November 20, 2018

SUBJECT: **Request for Modification of Section 404 Individual Permit and Section 401 Water Quality Certification** for the proposed Winston-Salem Northern Beltway Eastern Section from US 158 to I-40 Bus/US 421, Forsyth County, Division 9. WBS Element No. 34839.1.2, TIP Project No. U-2579B.

**Reference:** Section 404 Individual Permit – Action ID No. SAW-2008-03183, issued June 17, 2014 and modification issued July 2, 2014.  
Section 401 Water Quality Certification – NCDWR Project No. 2014090 issued April 11, 2014 and modification issued July 28, 2014.

PROJECT REFERENCE NO.	SHEET NO.
U-2579B	25
RW SHEET NO.	
ROADWAY DESIGN ENGINEER	HYDRAULICS ENGINEER

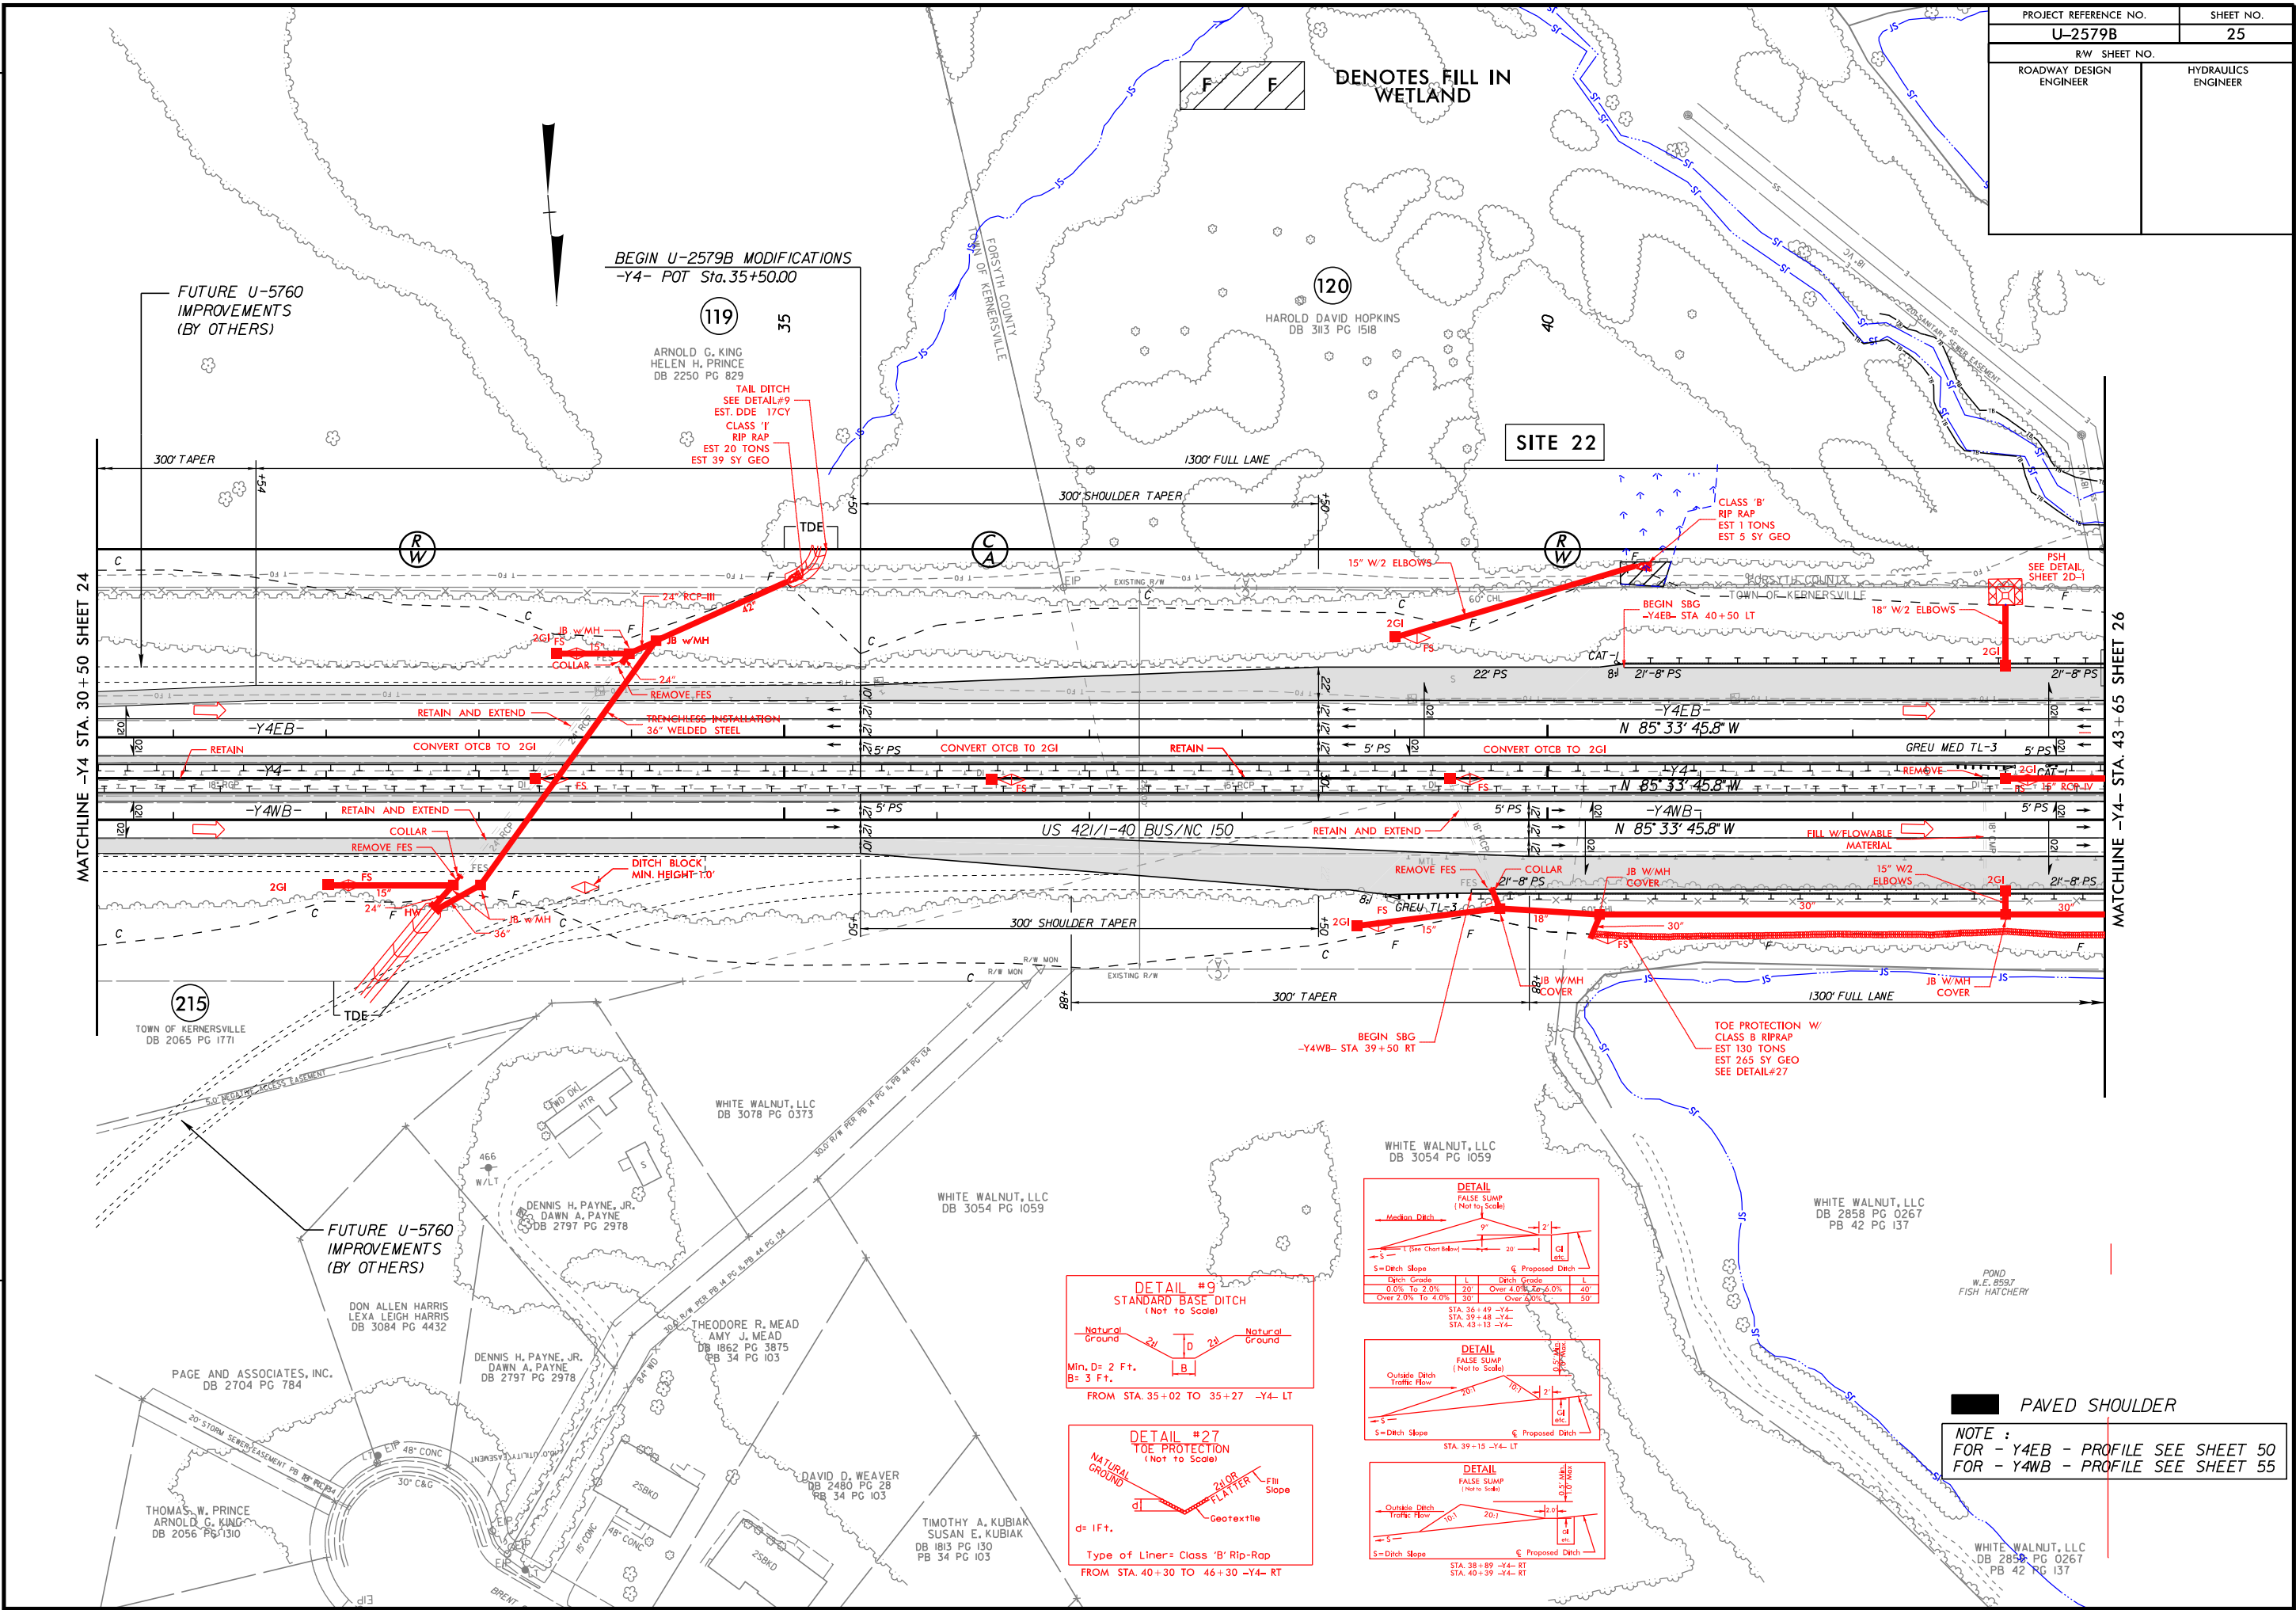
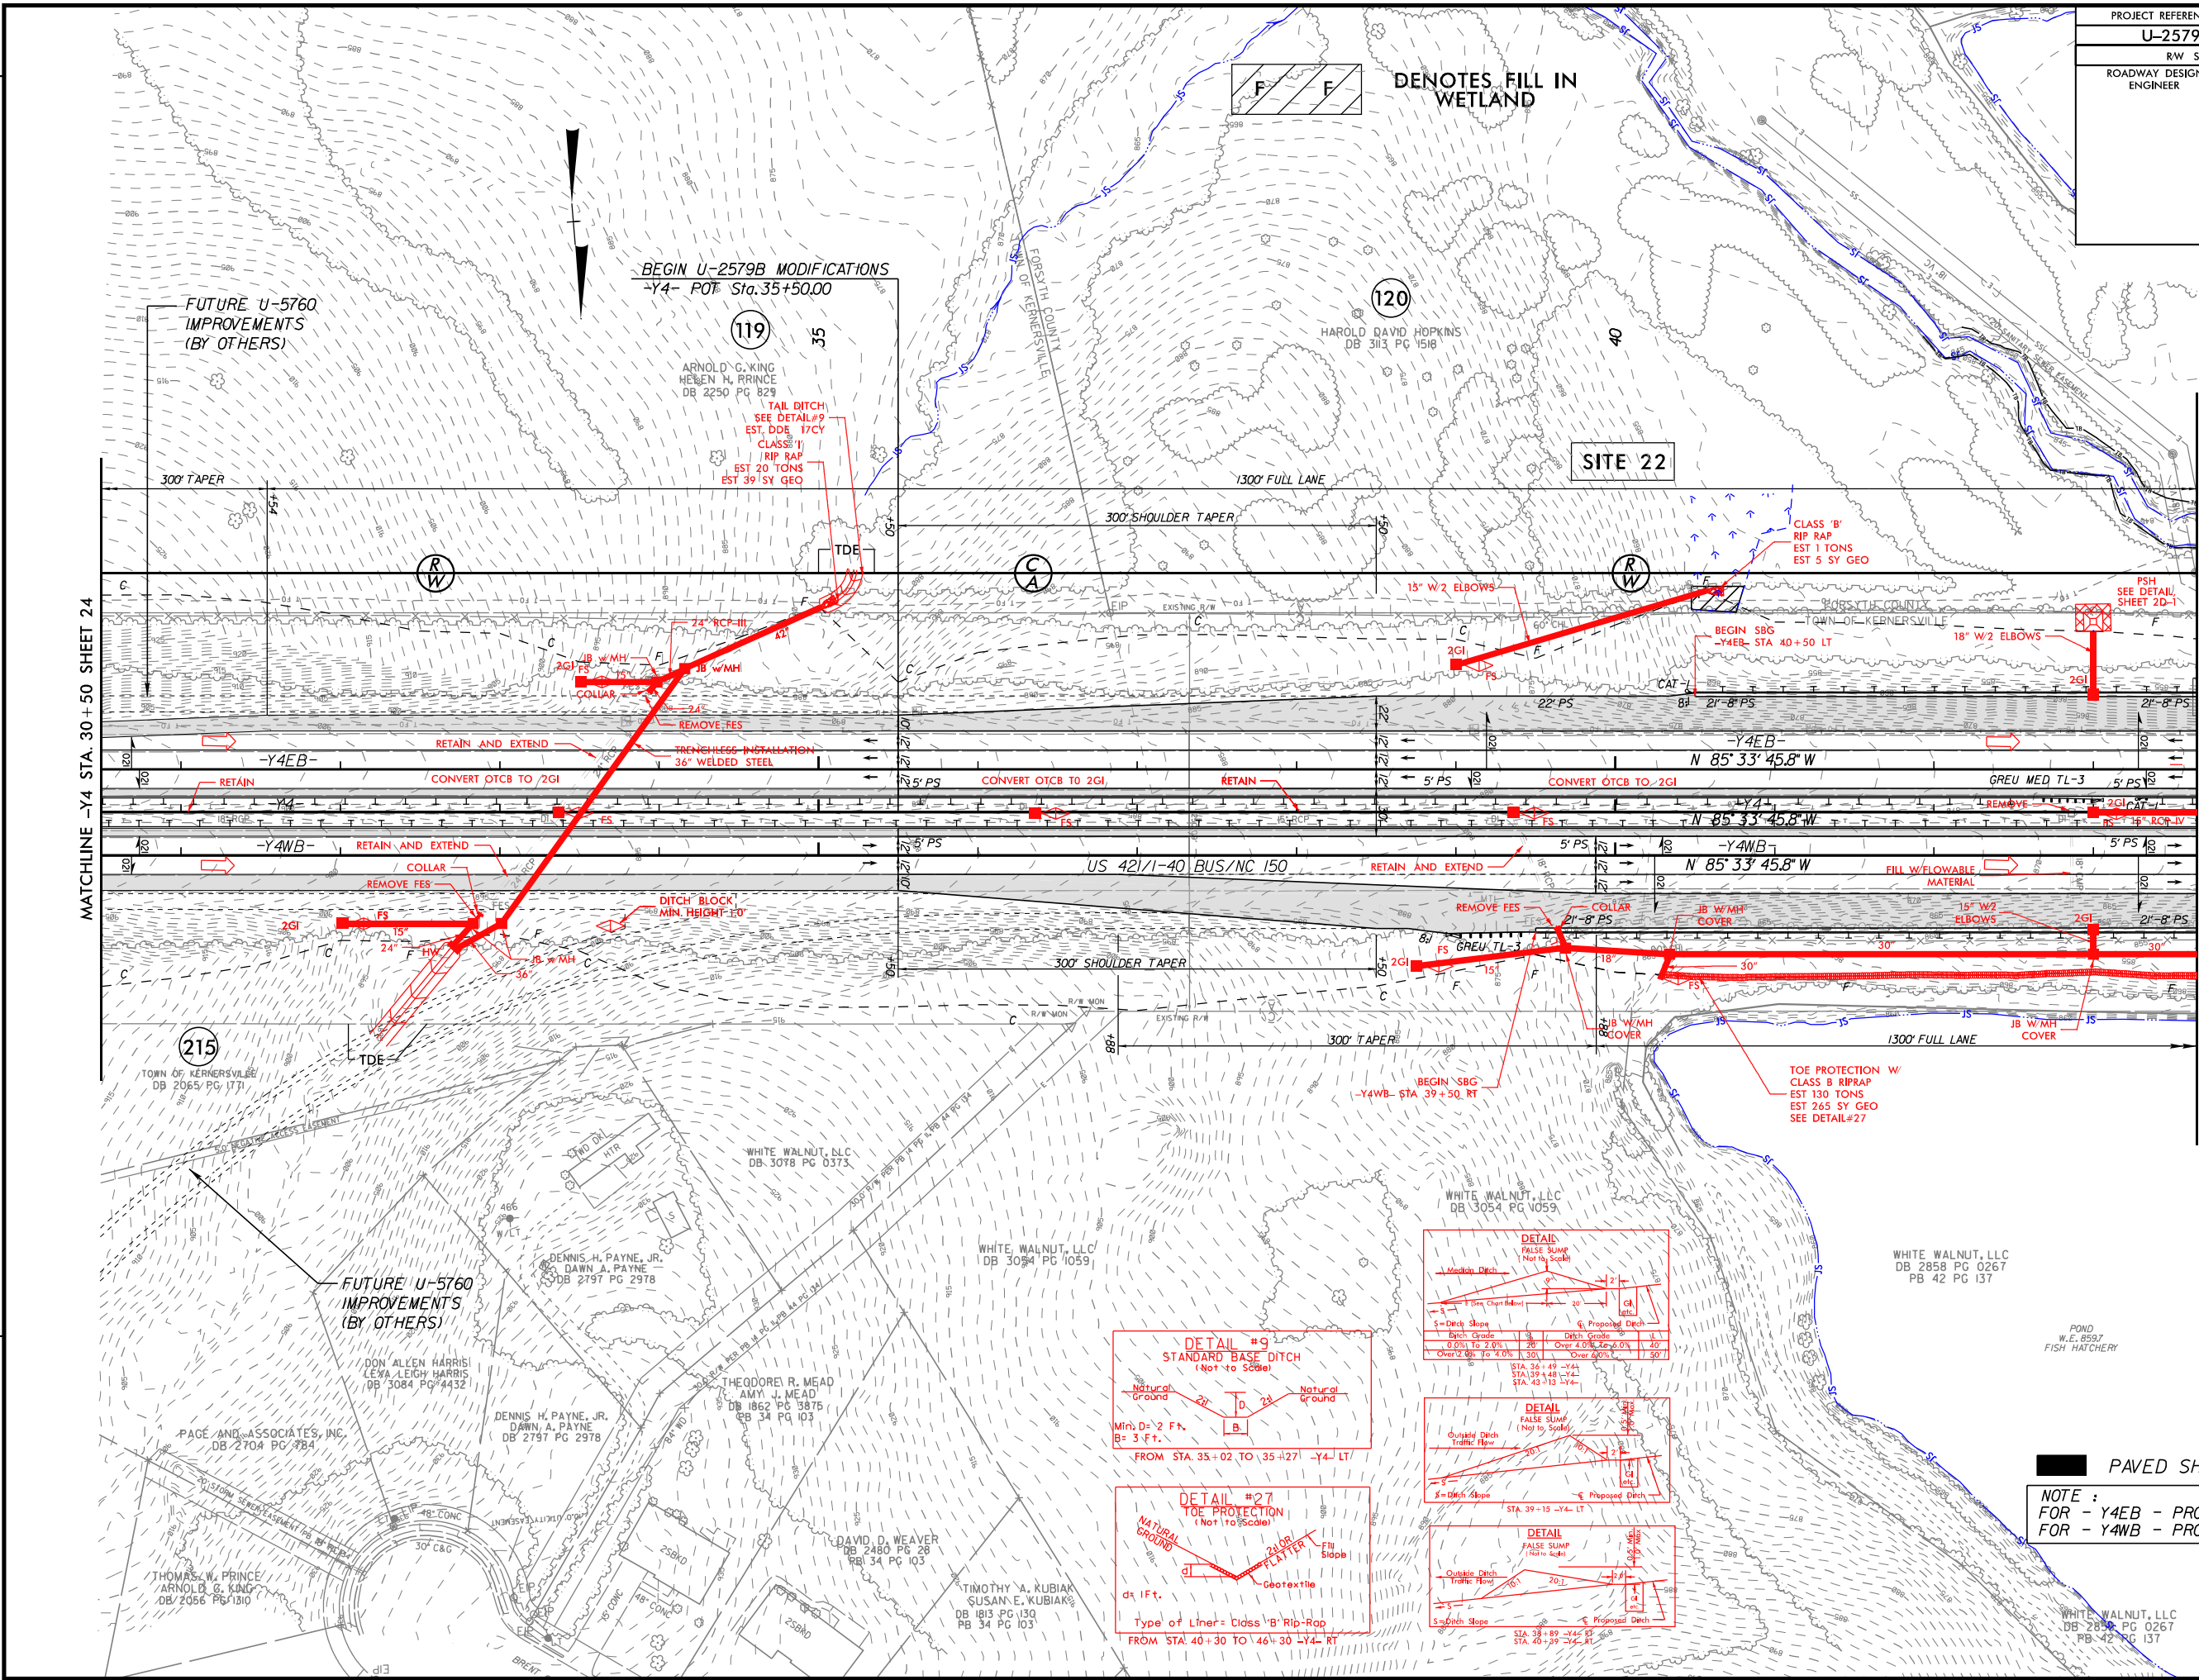
At sites 23 and 28, Smith Creek runs between existing westbound I-40 Business (US 421) and the adjacent ponds for the Windmill Fish Hatchery in a tightly restricted channel. We propose to extend the existing culvert at site 23 and place Smith Creek inside a 3 barrel box culvert at site 38. See Table 1 for previously permitted and revised impacts at permit sites 23 and 28.

Since Smith Creek was surveyed in 2008, the stream alignment has shifted closer to the road or the adjacent ponds in multiple location. In some areas adjacent to I-40 Business (US 421), Smith Creek has migrated to the toe of the existing fill for the roadway, and in other areas it has migrated into the toe of fill for the fish ponds. Due to the stream migration and instability, long term stability of the road fill and fish ponds are at risk. The permitted plans involved the construction of rock plating with retaining walls. However, when the fill slopes are extended for the guardrail installation and the onramp to the Winston Salem Beltway from I-40 Business/ US 421, the planned toe for the rock plating and walls are now in the active stream channel in some locations. If we installed the walls per plan, Smith Creek would be pushed in closer proximity to the ponds, and would threaten the stability of the ponds. Therefore, NCDOT plans to extend the existing triple barrel culvert under I-40 Business/ US 421 and install a triple barrel culvert in

Smith Creek between the road and the ponds. Additionally, the upstream end of the existing culvert will be lengthened by approximately 12' to accommodate traffic shifts during construction which will also result in a better alignment with the existing stream. These impacts were considered as part of the permanent impacts from the culvert extension in the original permit application, so the impact type won't change.
